- 19 [PR-CM] Development Application DA10/0222.26 for an Amendment to Development Consent DA10/0222 for Casuarina Town Centre Including 56 Lot Subdivision, Road Works, Infrastructure Works and Landscaping (Department of Planning Application MP06\_0258) MOD 10 a

This is the second report which has been brought to Council on MOD 10 to MP06\_0258 in regard to the Casuarina Town Centre (Council Reference DA10/0222.26). The first report was from 21 April 2016 in which concerns were raised with various elements of the proposed modifications (see attachment). Since this time the applicant has responded positively to Council's concerns and has invested a significant amount of time and resources into amending the proposal to address the matters raised.

The purpose of this report is to identify the changes that have been made since the original report and seek formal land owners consent from Council for the works within the "yellow" community land to the east of the town centre site shown below which is mapped as "community land".

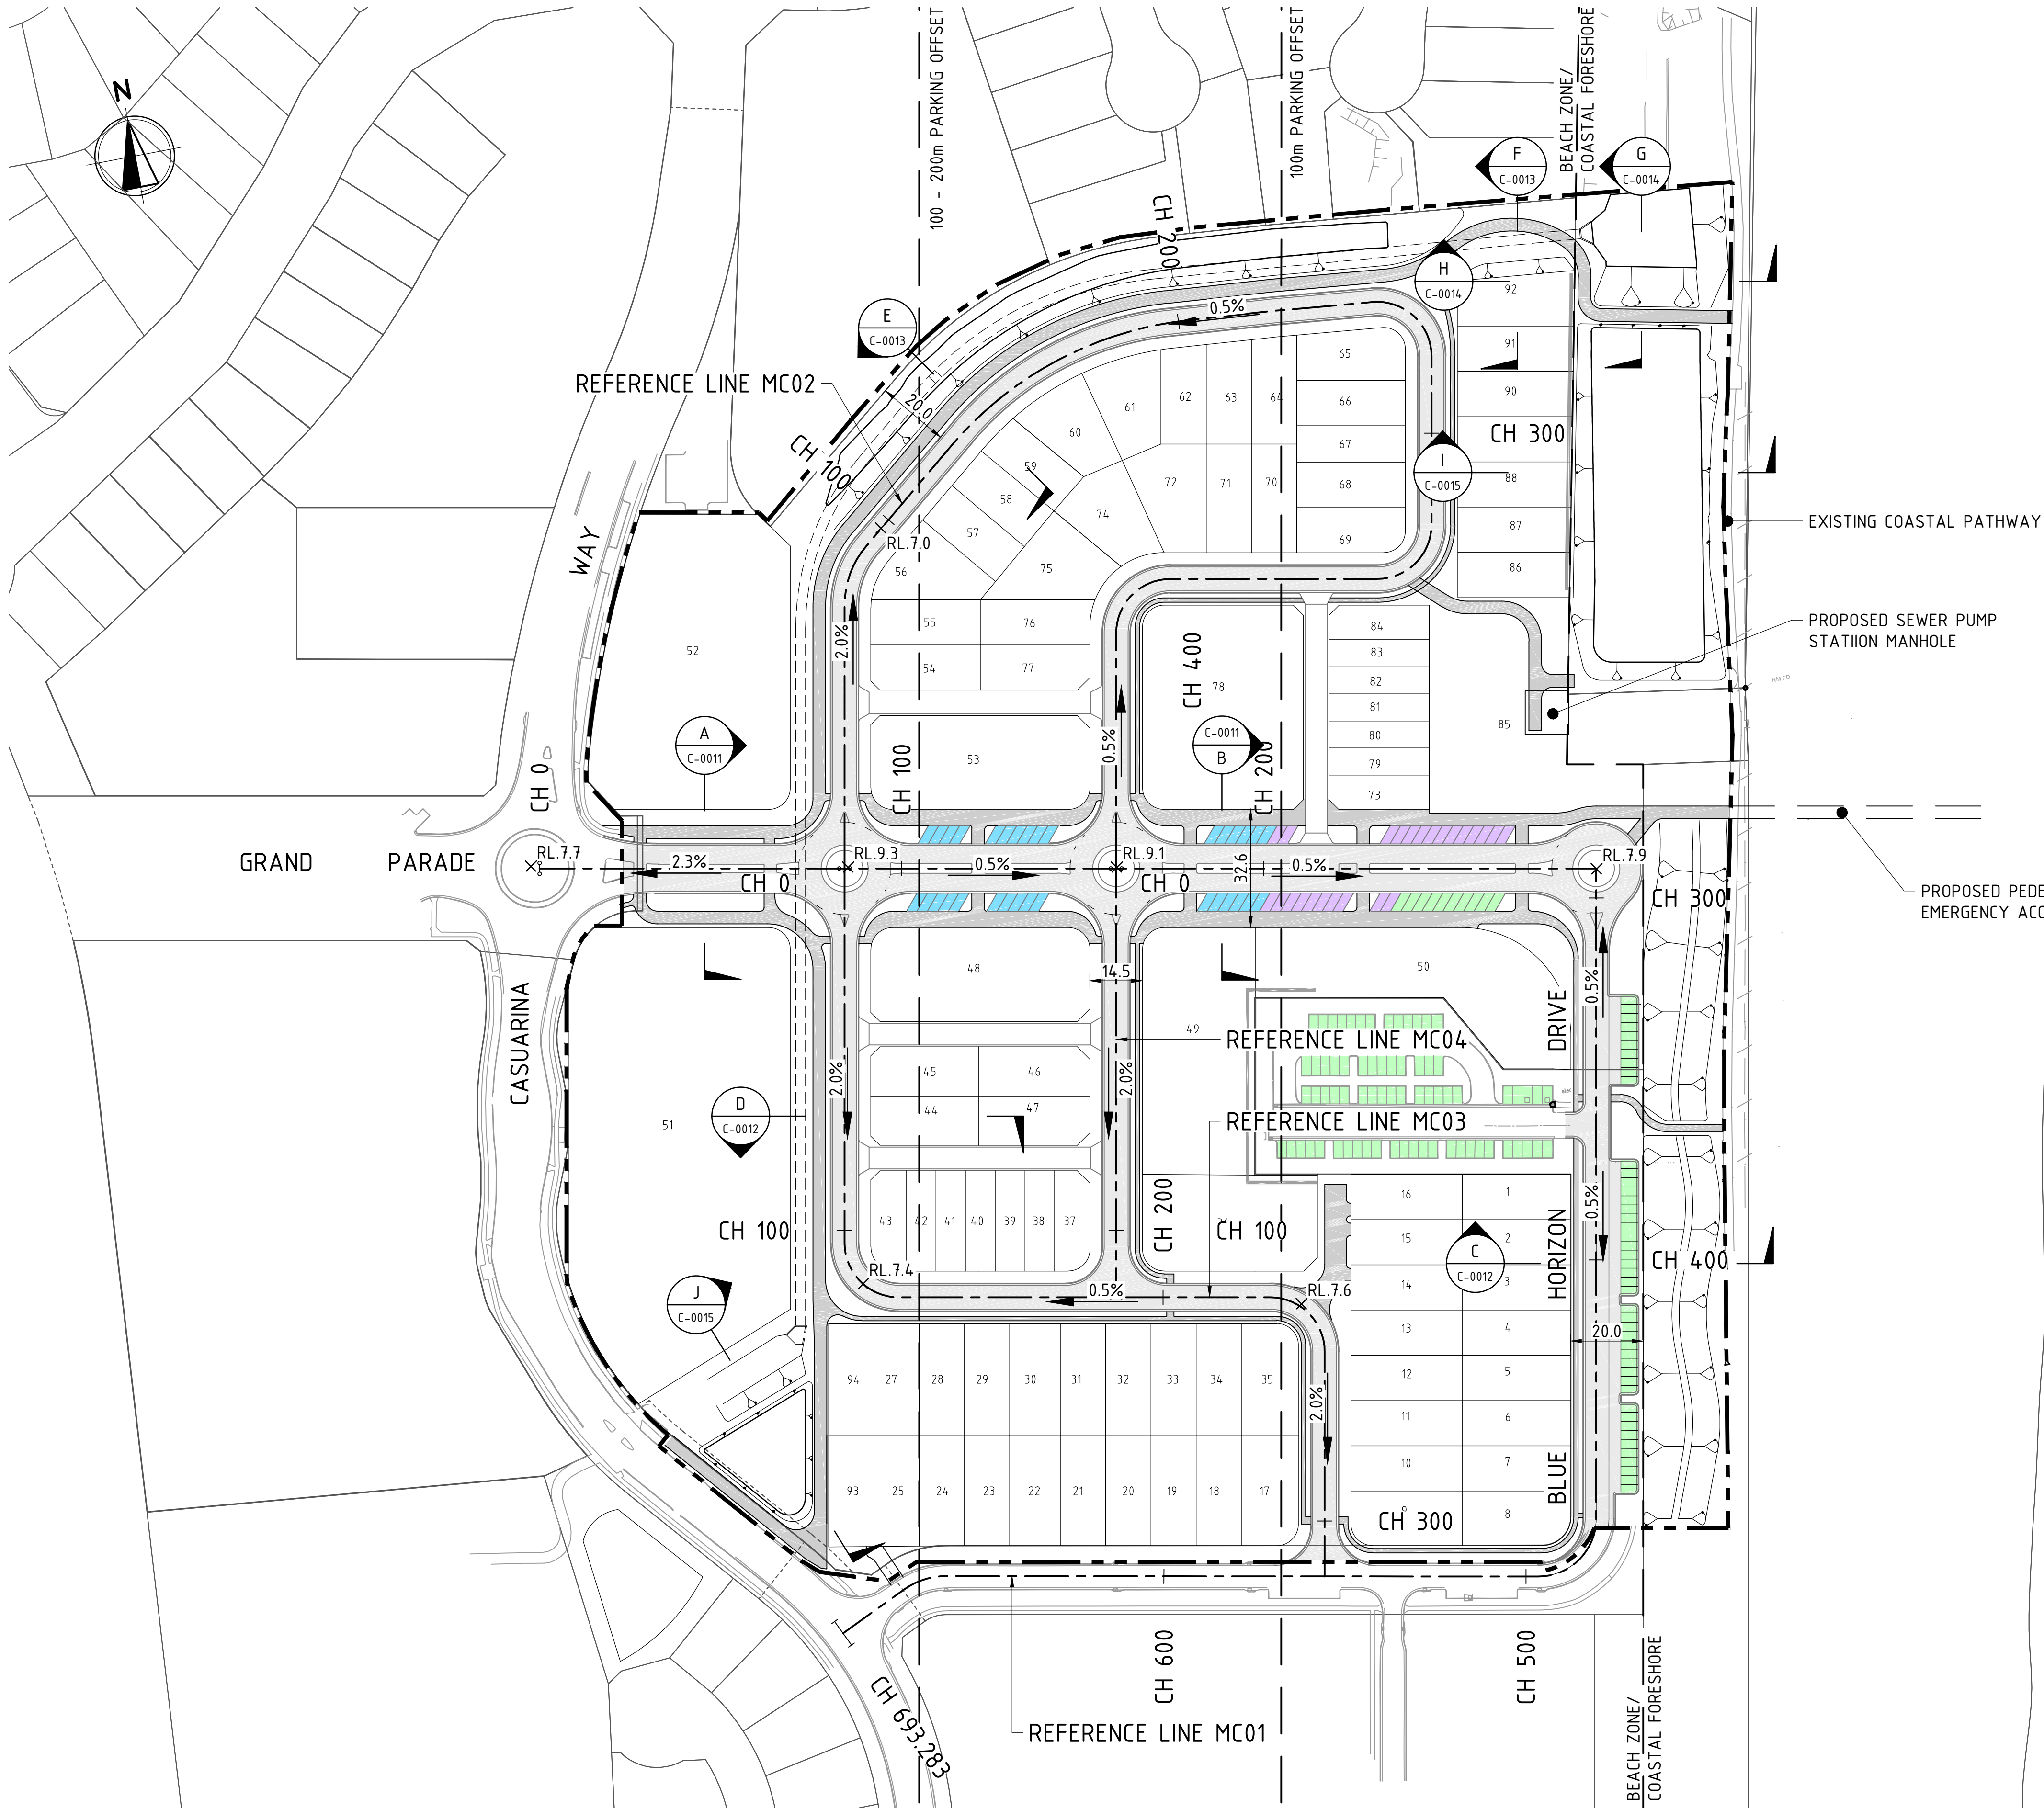
- The central concern expressed in previous assessment of material supplied by the applicant, is the adequacy of the east-west trunk stormwater drainage system. Currently this is provided by open channel and piped infrastructure within an easement benefitting Council, to convey major stormwater flows from the eastern coastal swale to the discharge point westward under Casuarina Way and Tweed Coast Road to Cudgen Creek. Previous MOD approvals have proposed to replace the swale with 3 x1650 culverts, and revised infiltration areas. However the subject MOD has sought to place other infrastructure and developable allotments in the northern portion of the site, and to reduce the constraints imposed by this stormwater infrastructure.

In a previous stormwater management plan, it was proposed to reduce the east-west drain to a single 1500mm pipe. While this was supported by modelling by the proponent's consultants, there was still concern about such a large reduction in pipe capacity. Accordingly, and at Council's suggestion, the proponent engaged a third party consultant to peer review the stormwater management proposal. This resulted in a revised design that provides a 2700mm x 1800mm box culvert through the site, and a reconfiguration of the stormwater infiltration basin within the eastern reserve. From an engineering perspective, this revised design satisfies previous concerns regarding capacity of the system to treat and convey stormwater flows from internal and external catchments. It is noted that the revised earthworks and levelling of the coastal strip provides less intrusive earthworks design, with reduced retaining walls, batter slopes and inlet structures. While many of these works will be carried out on community land (and requires approval via a revised management plan), this proposal is considered acceptable for submission to the Department of Planning.

TITLE		
SITE LAYOUT PLAN		
PROJECT No. B16097	DRAWING No. C-0003	REV A

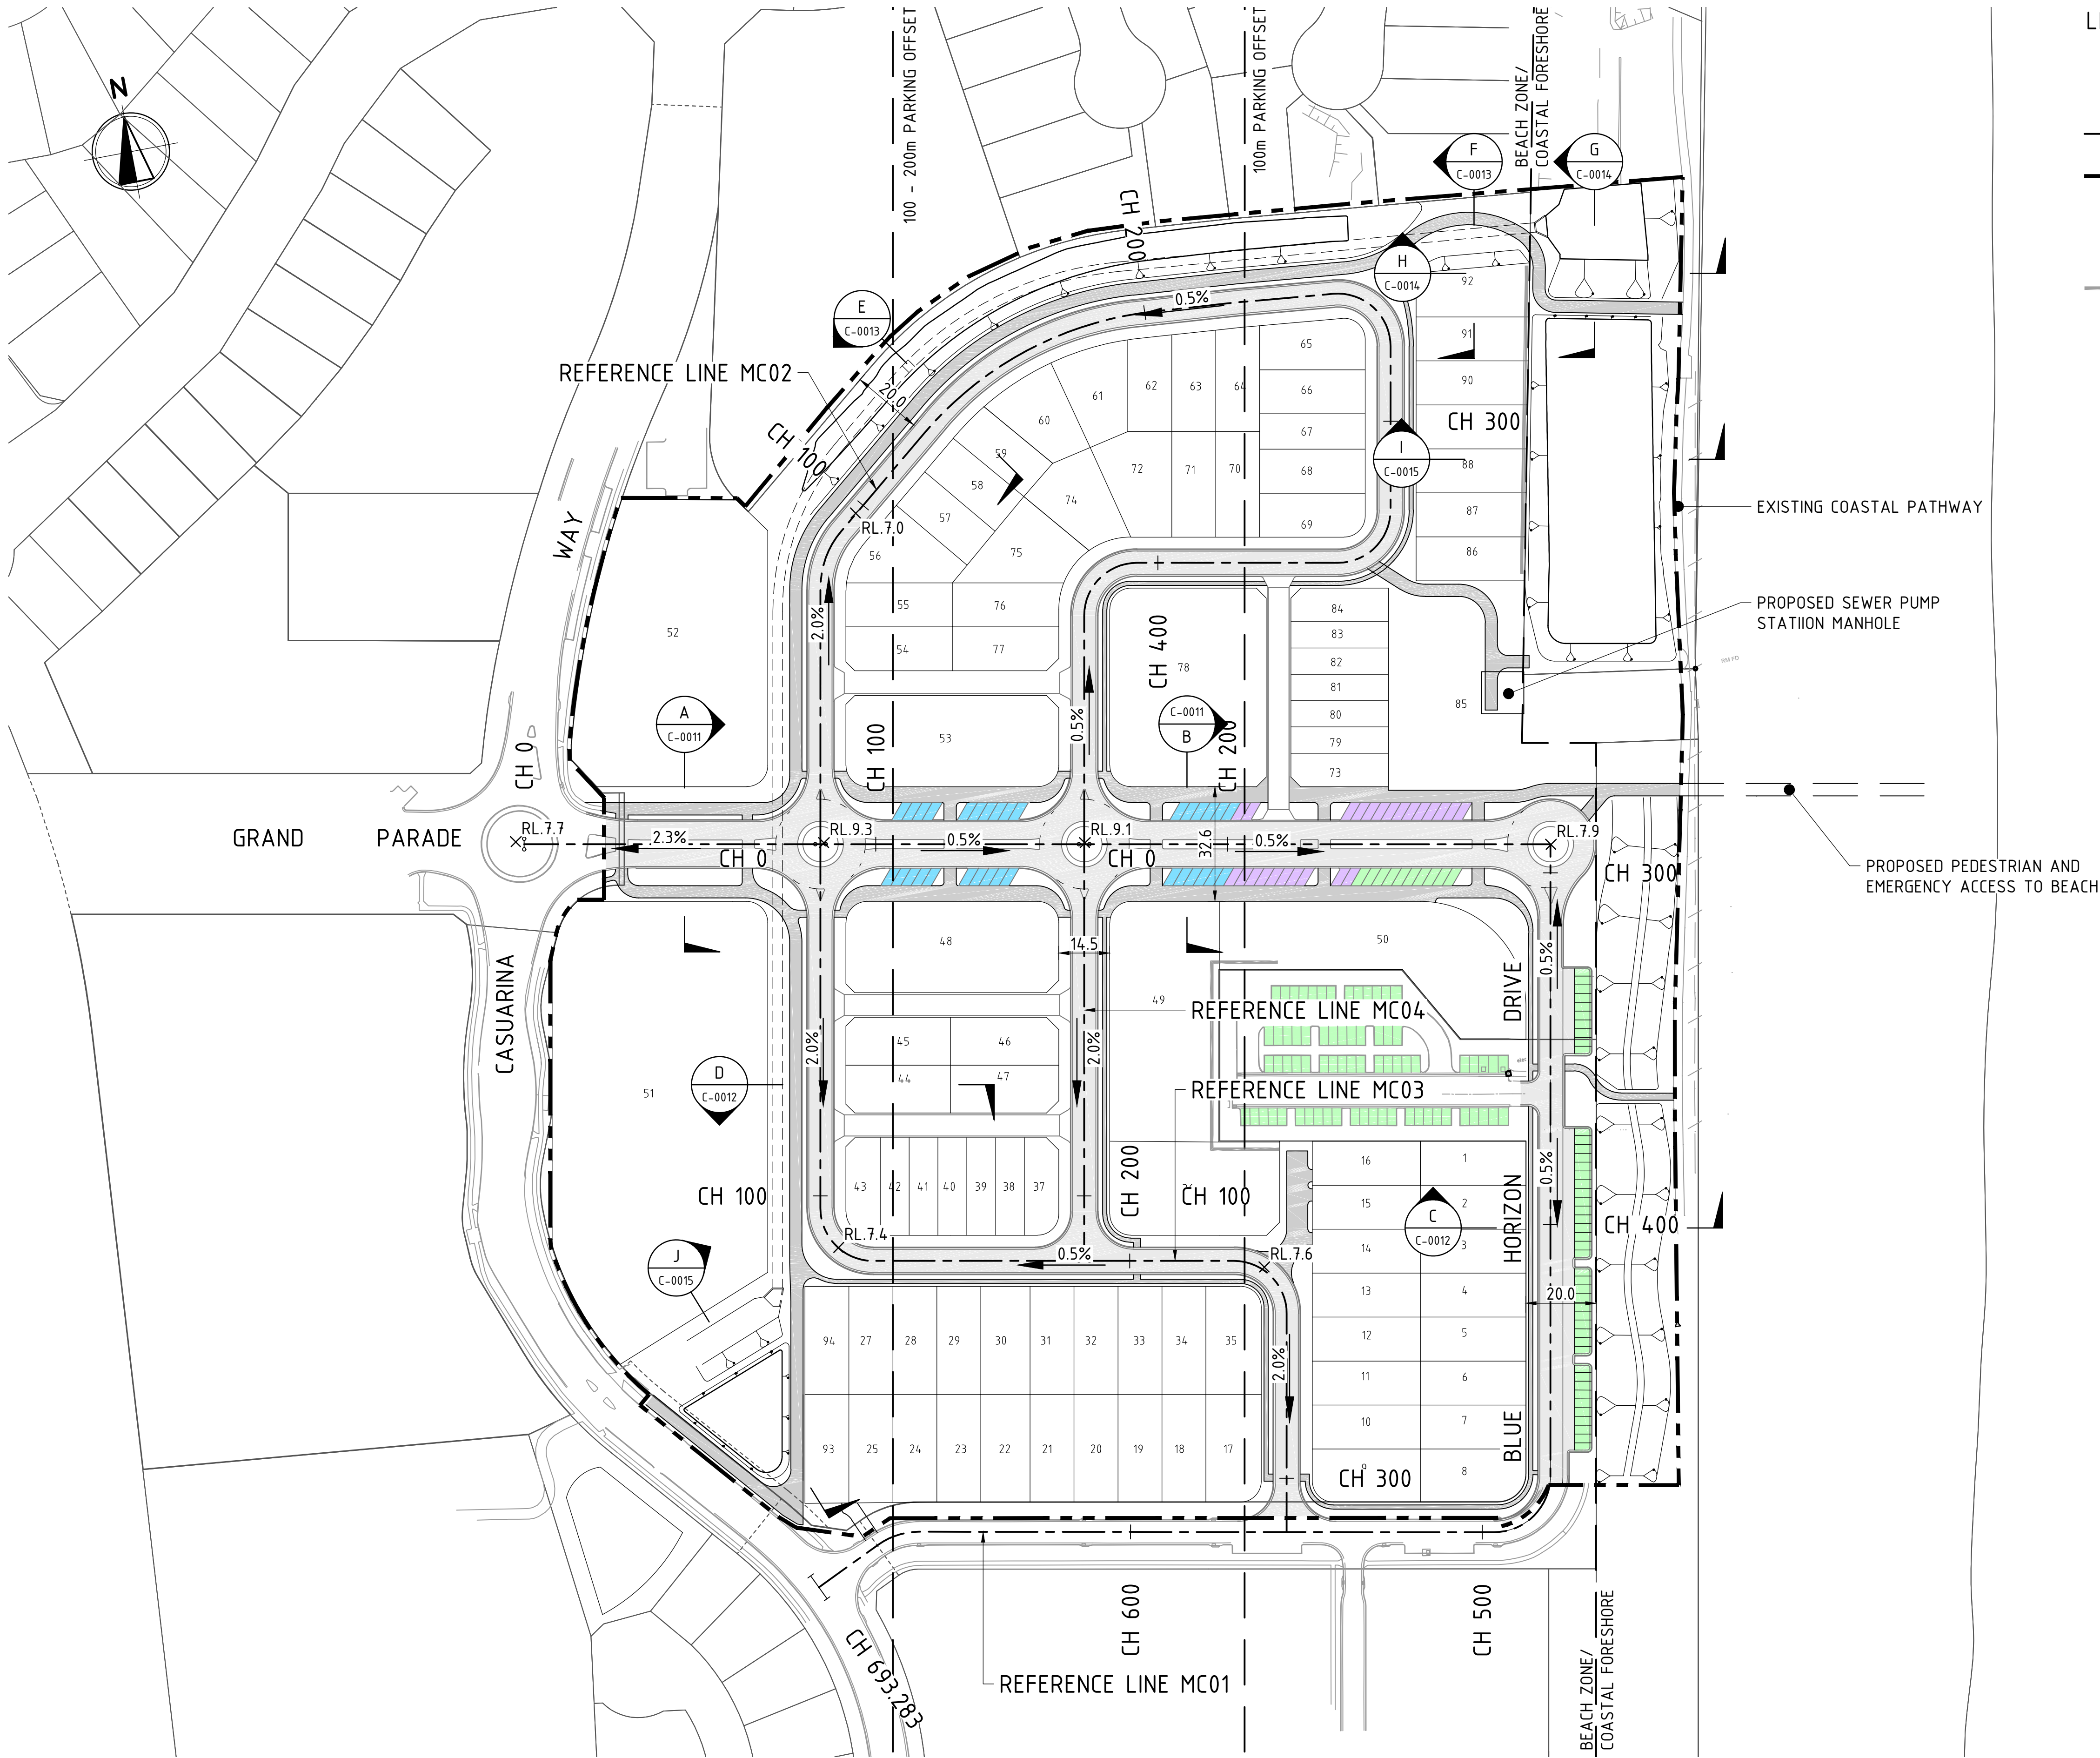
- An updated earthworks/land forming engineering plan has now been provided by BG&G which ultimately reduces the number of retaining walls across the site to a total of three (3). All the proposed retaining walls are proposed to be a maximum of 1 m in height; hence the previous retaining wall of 4m has been removed. All proposed retaining walls are now within private property and comply with Tweed Shire Councils Development Design Specification - 06 Site Regrading (TSC-D6) specifies that the maximum permissible combined of retaining walls or batters in residential subdivisions. The proposed earthworks and retaining walls are now accepted.
- The updated drawings issued by BG&E indicate that Grand Parade road reserve is now 32.6m wide and has a paved verge of 4.5m wide as per the image below.

- The updated drawings show an additional 24 car spaces in the beach parking area as required.
- The revised location for the sewerage pump station meets the setback requirements for residential environment and can be accessed for maintenance.
